**CITY OF PORTLAND**

FROM: MARGE SCHMUCKAL, ZONING ADMINISTRATOR

SUBJECT: SECTION 14-436 BUILDING EXTENSIONS  
9 ADAMS STREET – PEAKS ISLAND - 084-F-012 – IR-2 ZONE

DATE: MAY 13, 2002

9 Adams St. Peaks Island
Third-Story Tower Addition

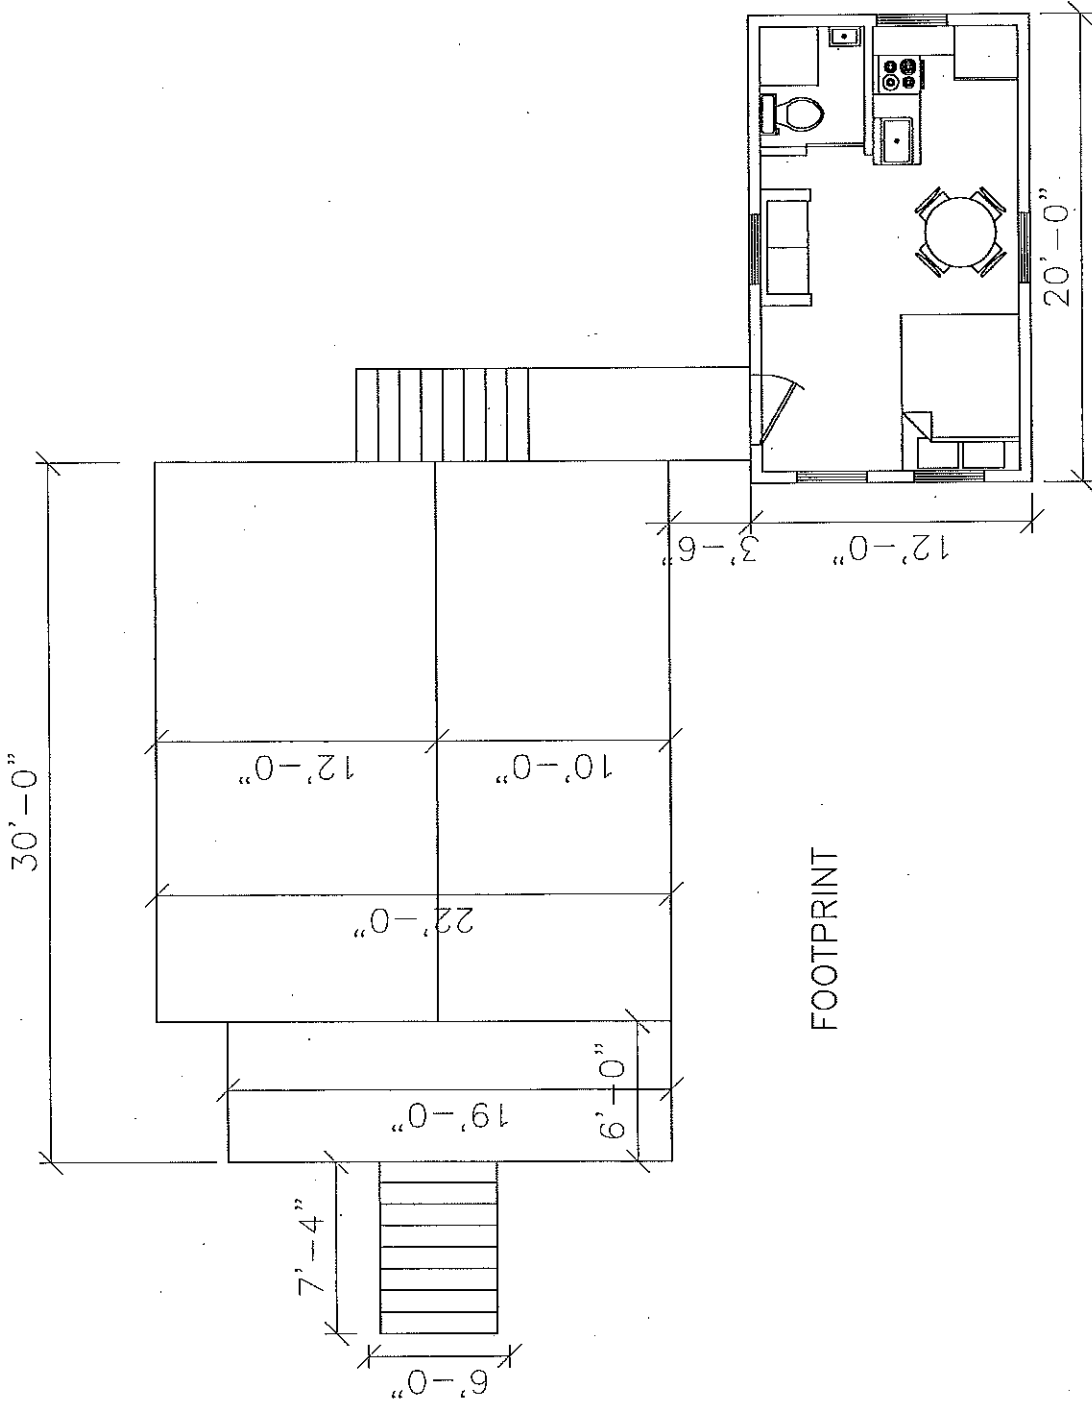
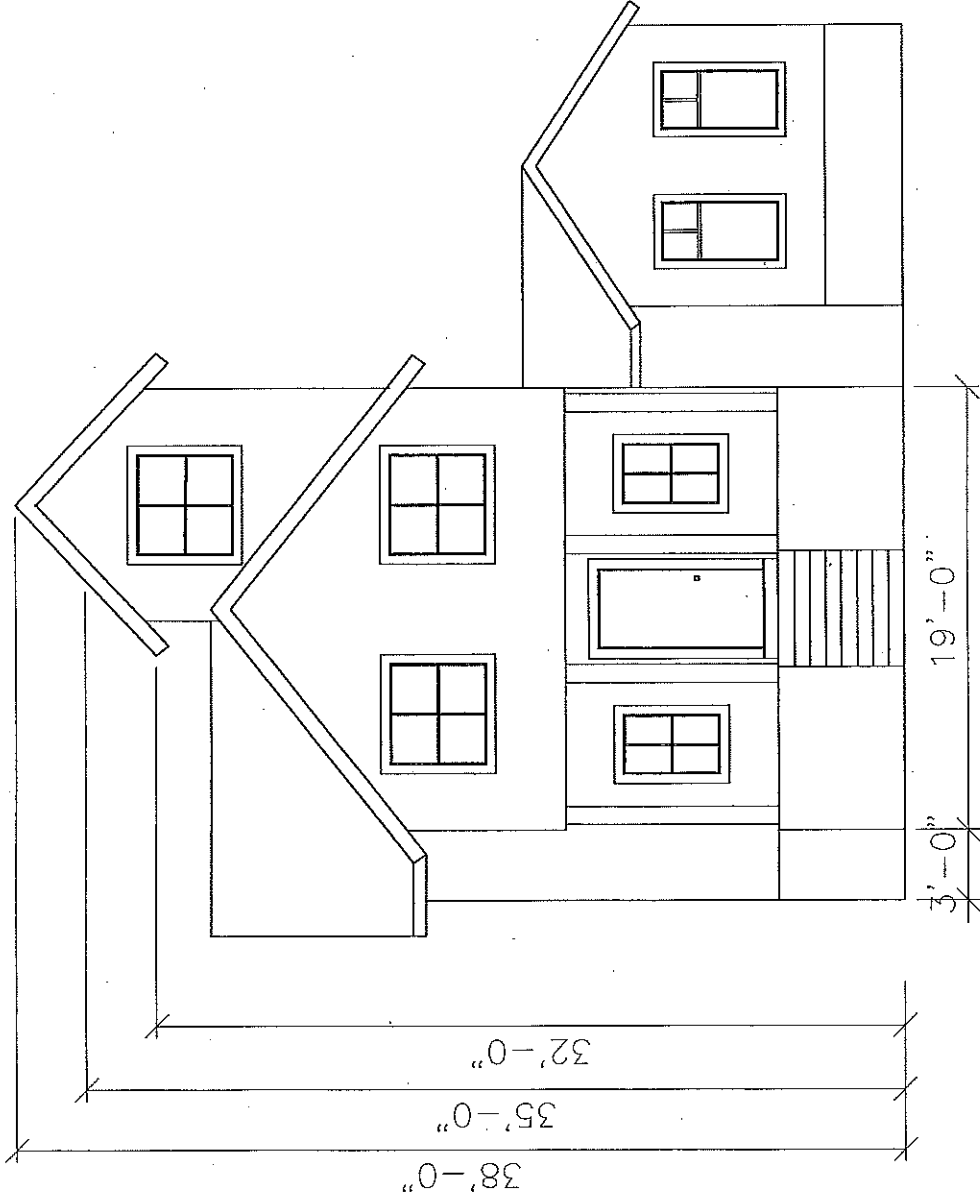
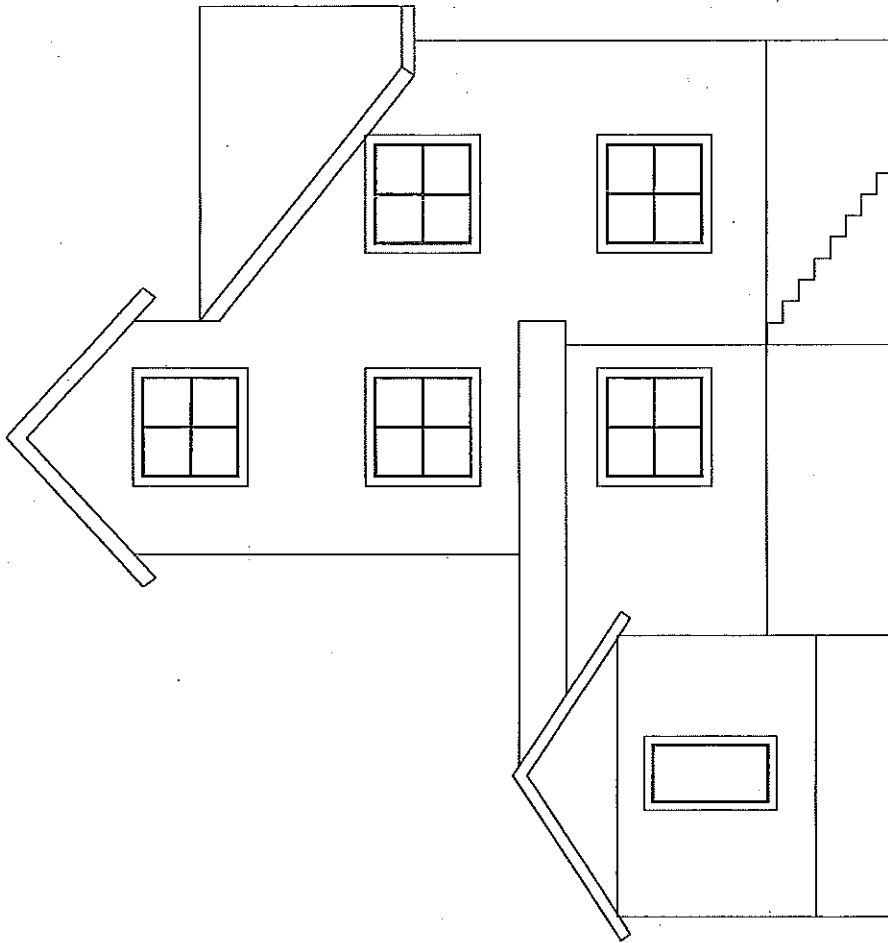
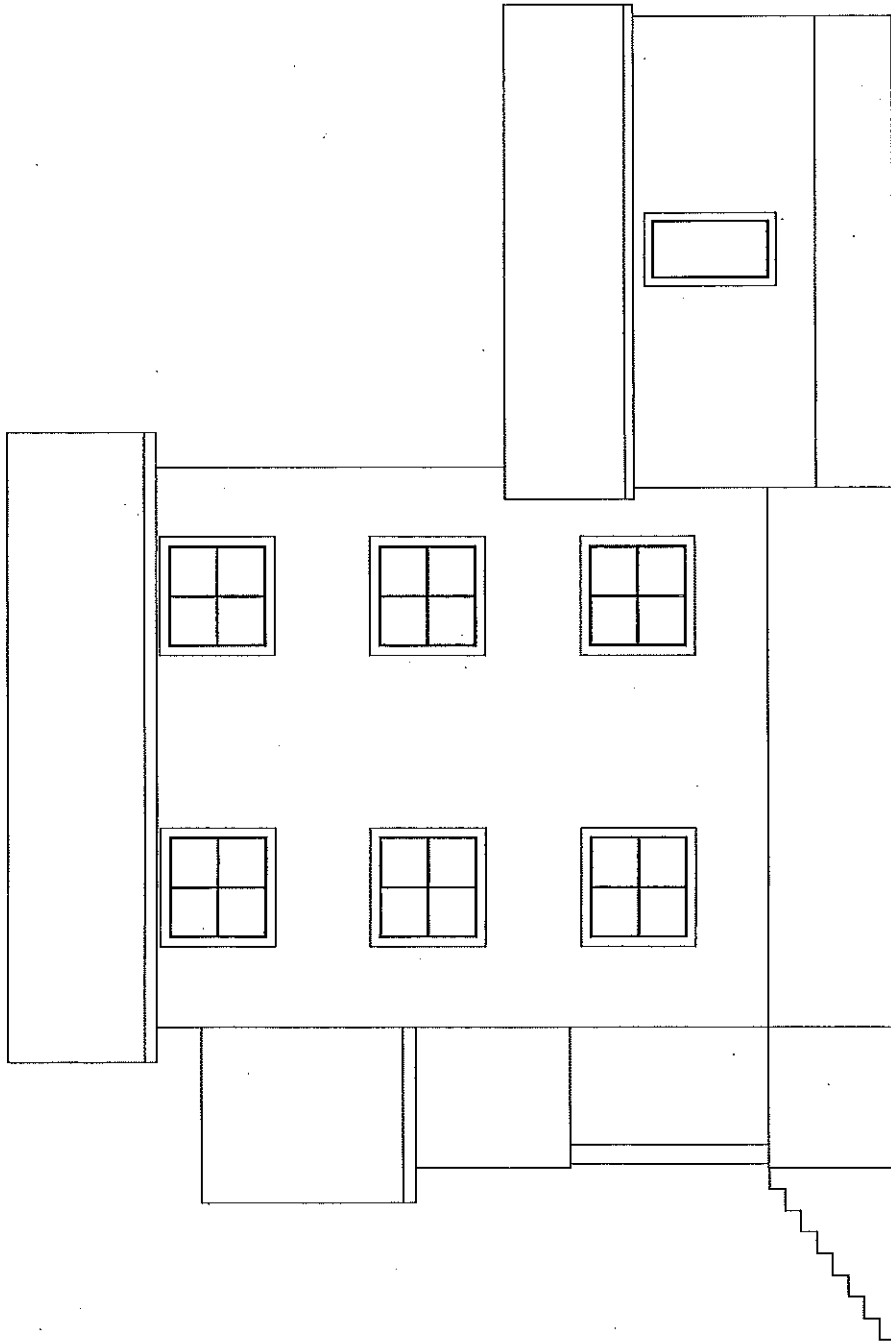
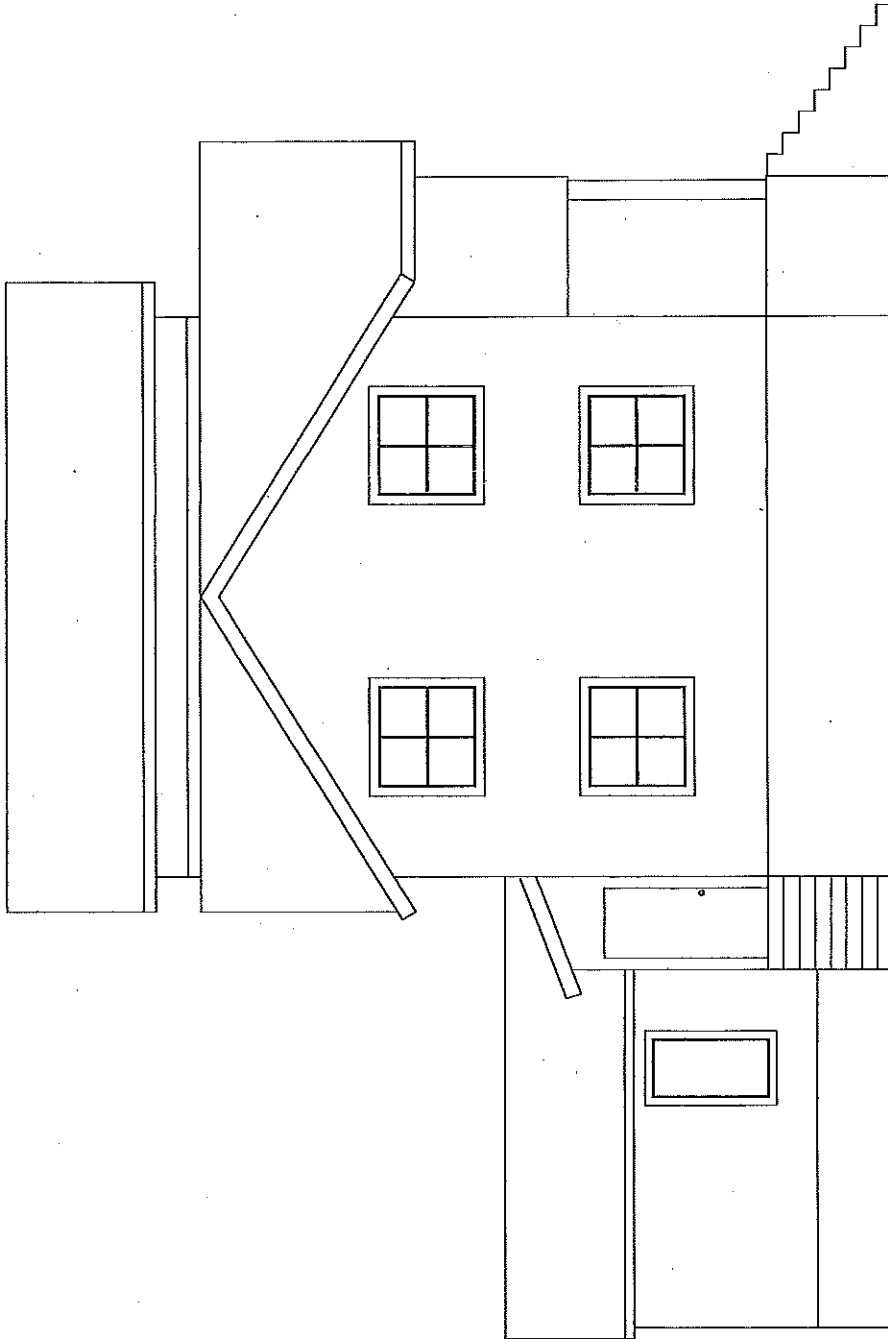
The ordinance is very specific as to how this limited expansion is to be allowed. It states that, "the additional floor area shall be created in the uppermost floor by the use of dormer, turrets, or similar structures need to provided the minimum height required for habitable space, while preserving the existing roof configuration to the maximum extent possible." It does not allow a further expansion beyond that into another floor above the existing roof line. The owner contends that because the newly proposed third floor turret is setback the required 20 feet on the side yards, it is conforming to the ordinance setbacks. I believe that you must look at the entire structure and its setbacks, not individual portions of the structure. I also believe that section 14-

436 limits the allowed expansion. It does not state that you can also go up higher with another story if you meet the current setbacks. The ordinance is quite specific as to restricting the expansion upward. Therefore, I would not allow the expansion of the addition turret on the third floor under section 14-436.
